**Arthur Philip High School and Parramatta Public School, Parramatta (SSD 7237)
Notice of Exhibition**

TAB A – Request for Further Information/Clarification

DRAWING
GENERAL ARRANGEMENT
FLOOR PLANS PPS - GA -
GROUND - CHARLES
STREET
DRAWN KN
CHECKED AB
AUTHORISED N/A

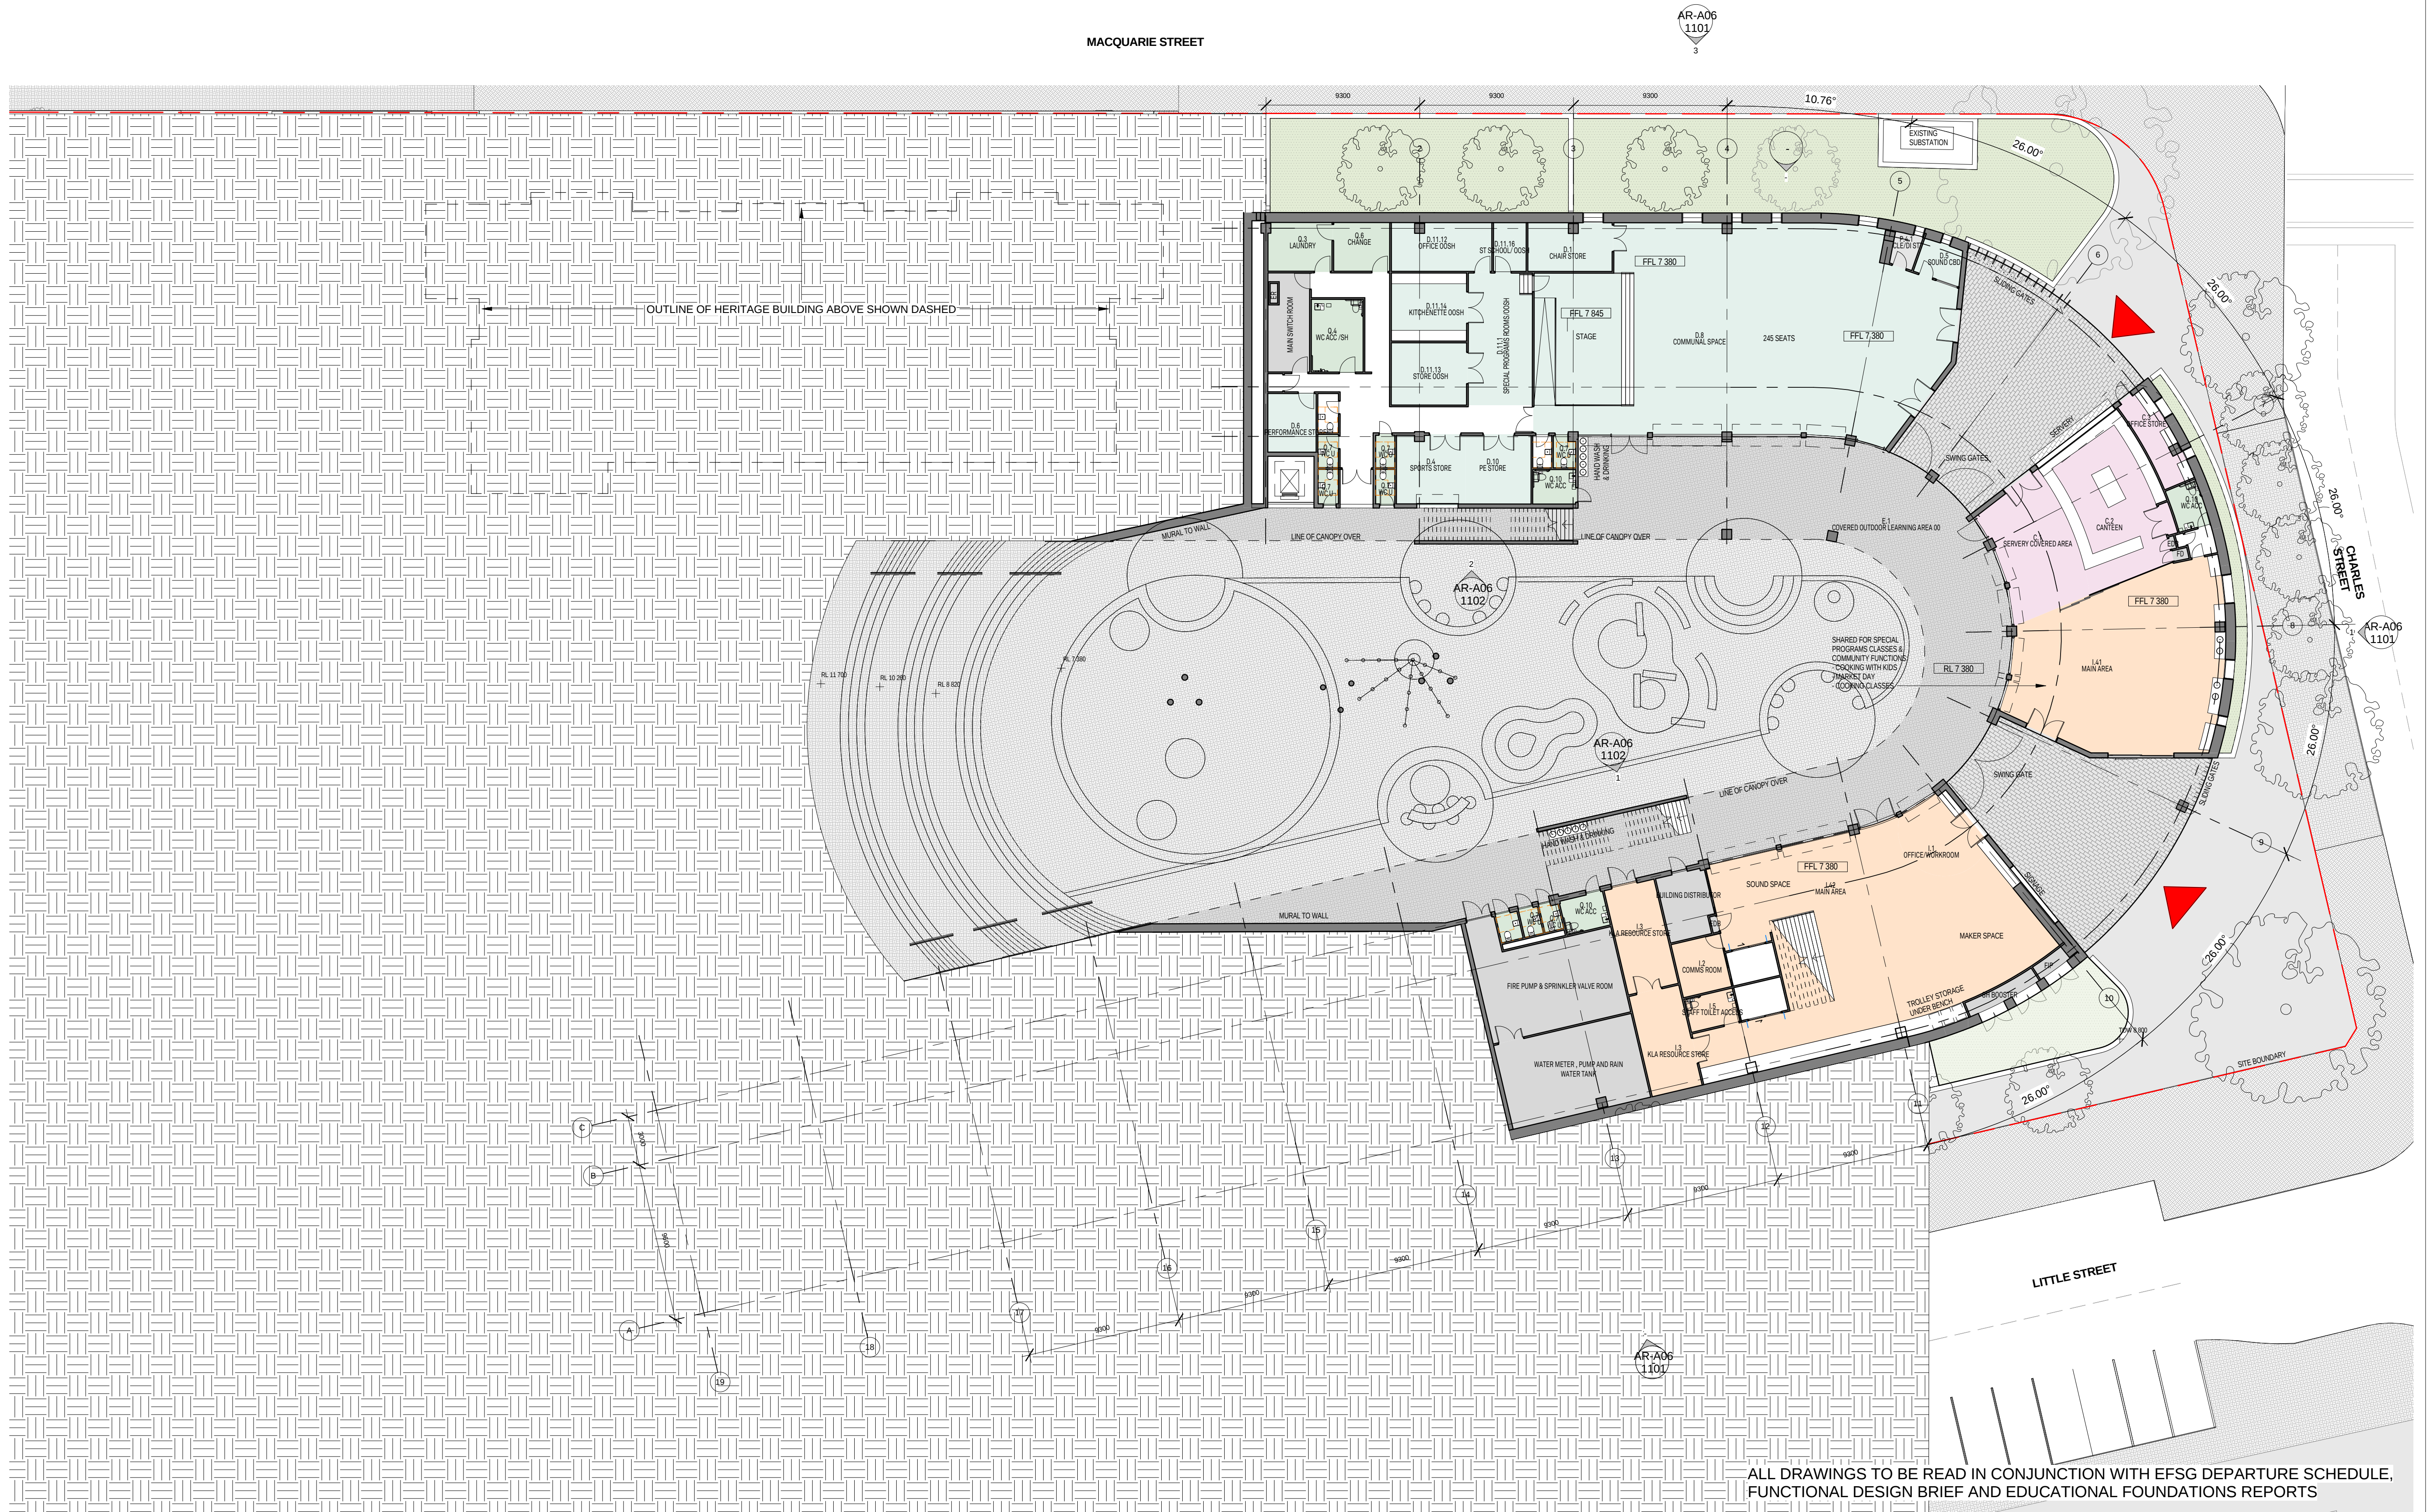
Swept path analysis is required to demonstrate that service vehicles can enter/exit the proposed loading areas and access driveways (subject to light rail consideration above). Swept path analysis should also show that buses can travel to and from the relocated part-time bus zone on Charles Street without blocking through traffic.

TfNSW recommends that swept path analysis for service vehicles and buses should be provided.
